**Your Ref: 2021/1405
Our Ref: X020866**

29th November 2021

Former William Freeman Site, Wakefield Road, Mapplewell, Barnsley - Reserved matters (appearance, landscaping, layout and Scale) application for development of 102 homes, structural planting and landscaping, surface water attenuation and associated infrastructure in connection with outline planning permission 2017/1718 (Outline planning for up to 102 homes)

Drawn	RT	Chkd	AD	Date	SEPT 21	Scale	1/500
Contract No.	21524-DR-C	Dwg No.	0100	Revision	P1

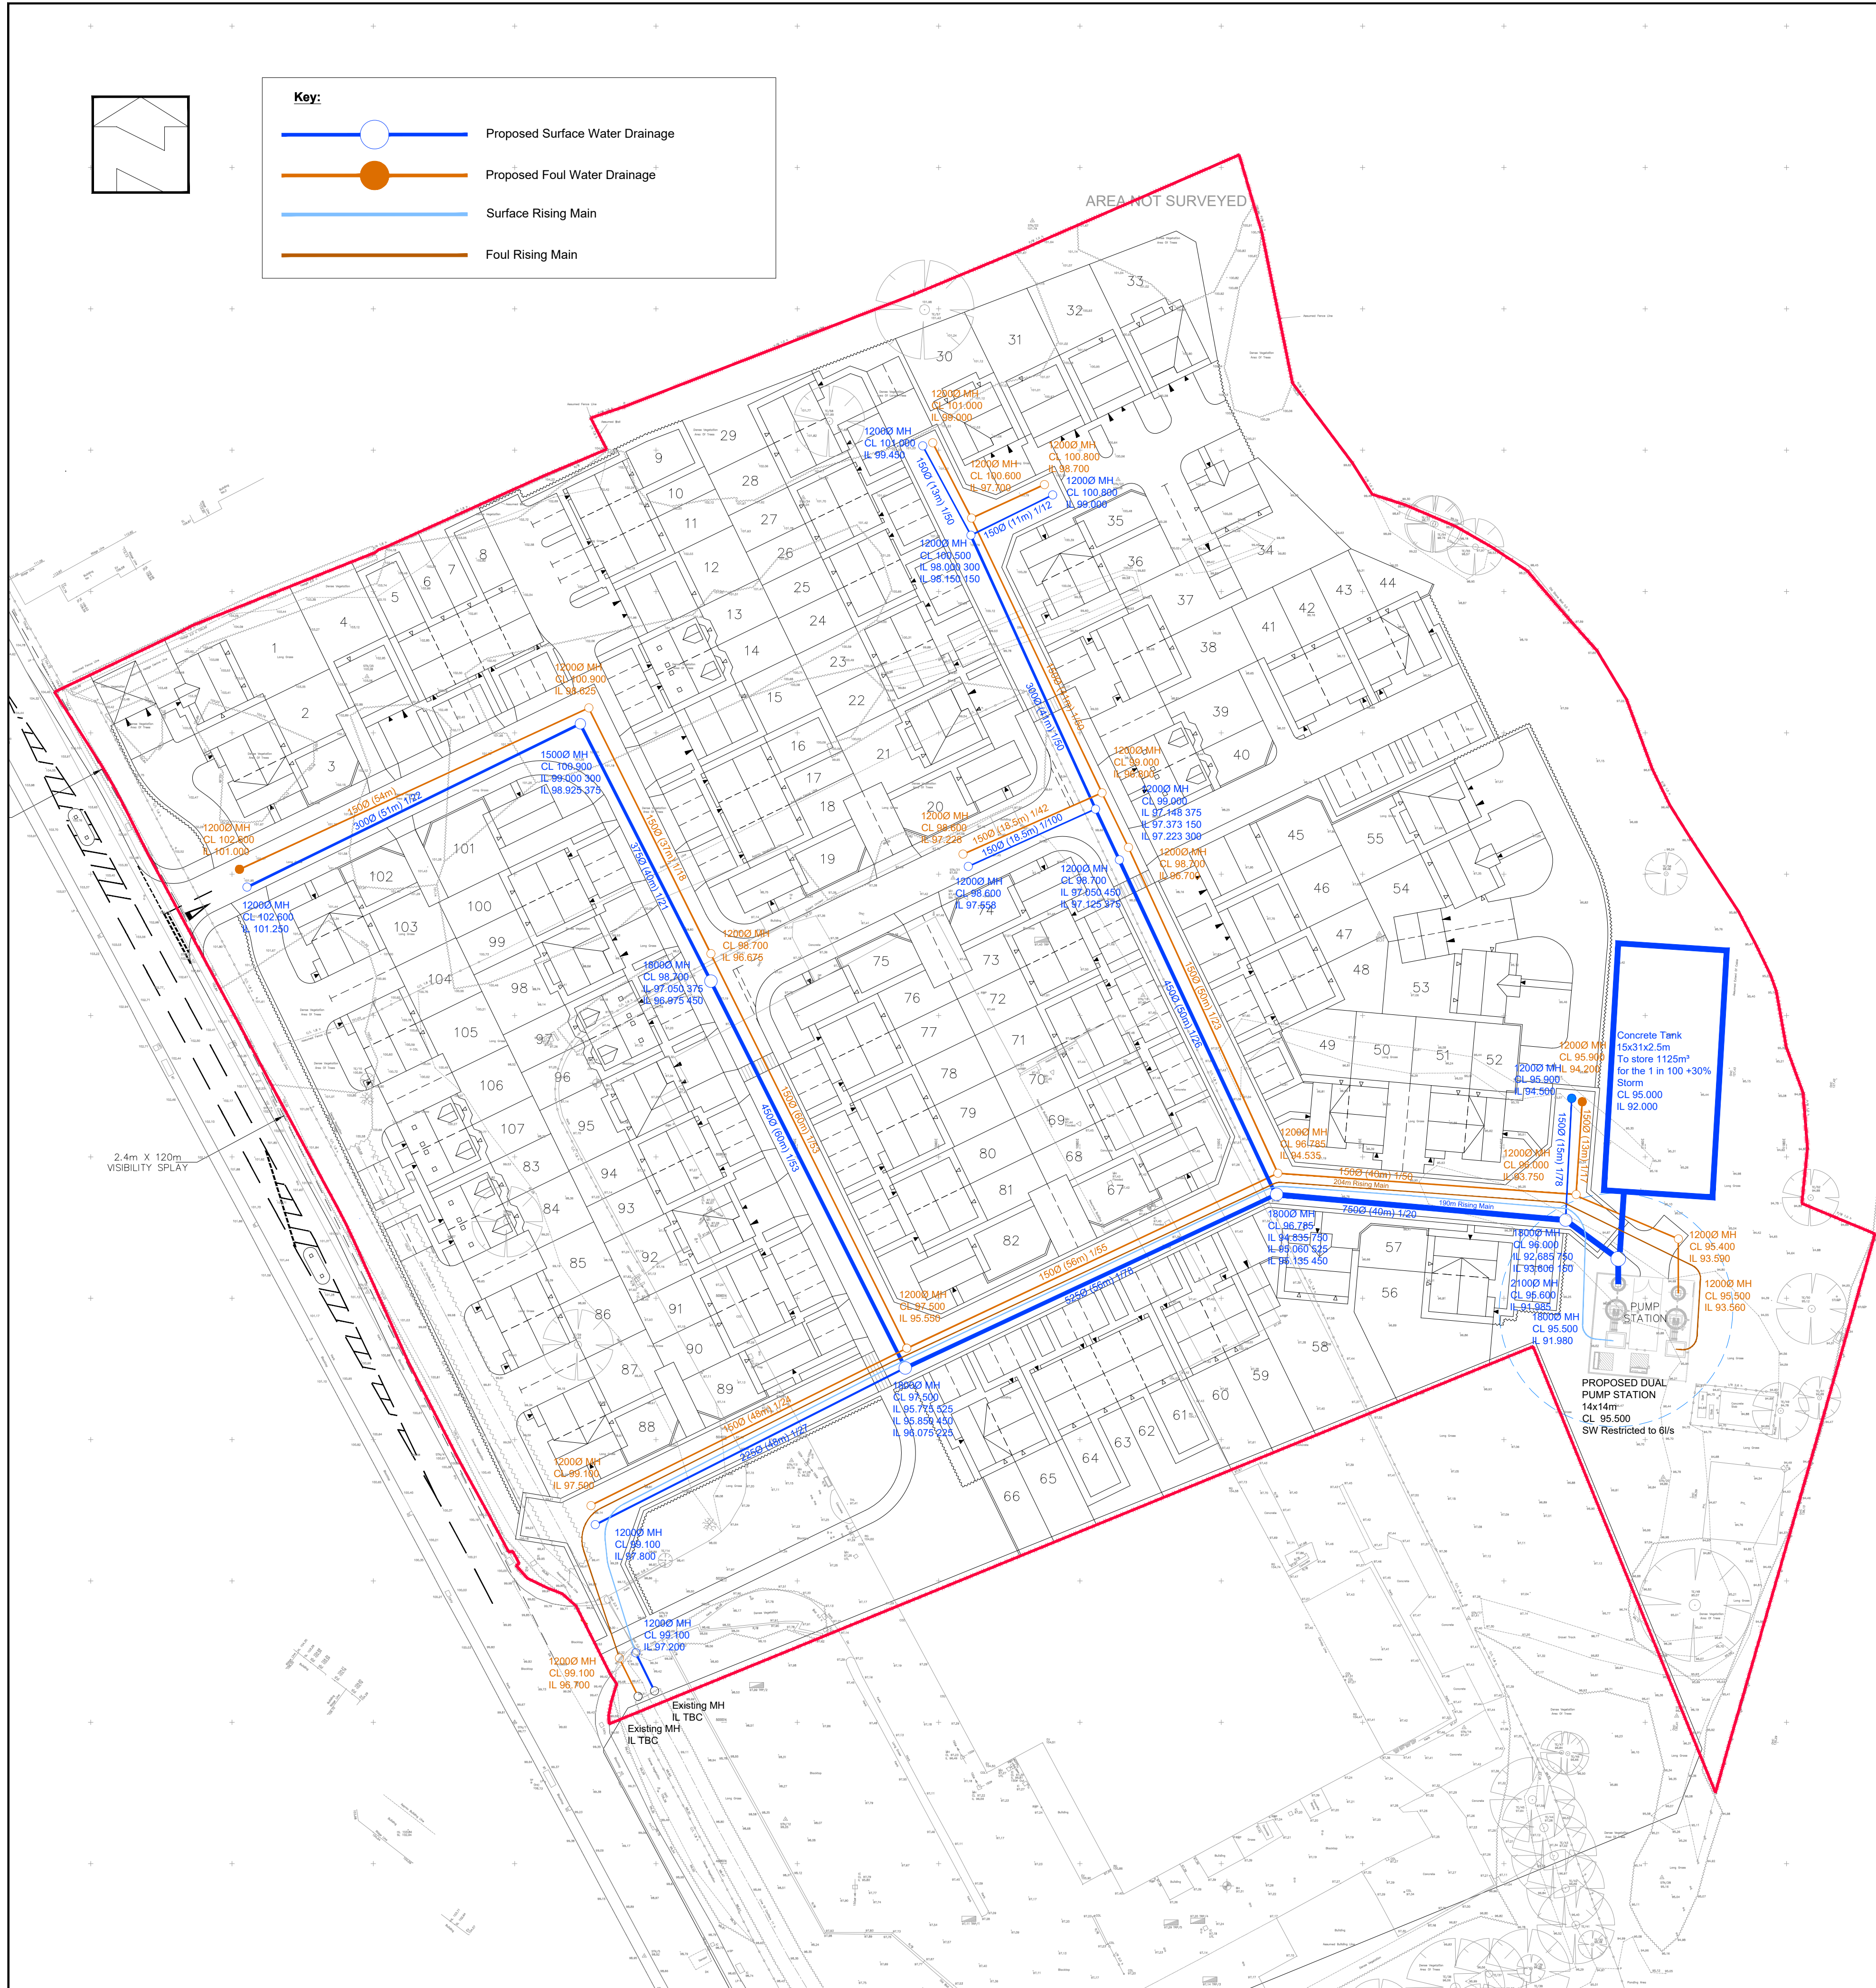
1.) Yorkshire Water has no objection in principle to the drainage details submitted on drawing 21524-DR-C 0100 (rev P1) dated 28/09/21 that has been prepared by Topping engineers, namely:

- a.) The proposed separate systems of drainage on site and off site.
- b.) The proposed amount of domestic foul water to be discharged to the public foul/ water sewer
- c.) The proposed amount of curtilage surface water to be discharged to the public combined water sewer at a pumped rate of discharge not to exceed 6 litres per second.
- d.) The proposed point(s) of discharge of foul and surface water to the respective public sewers
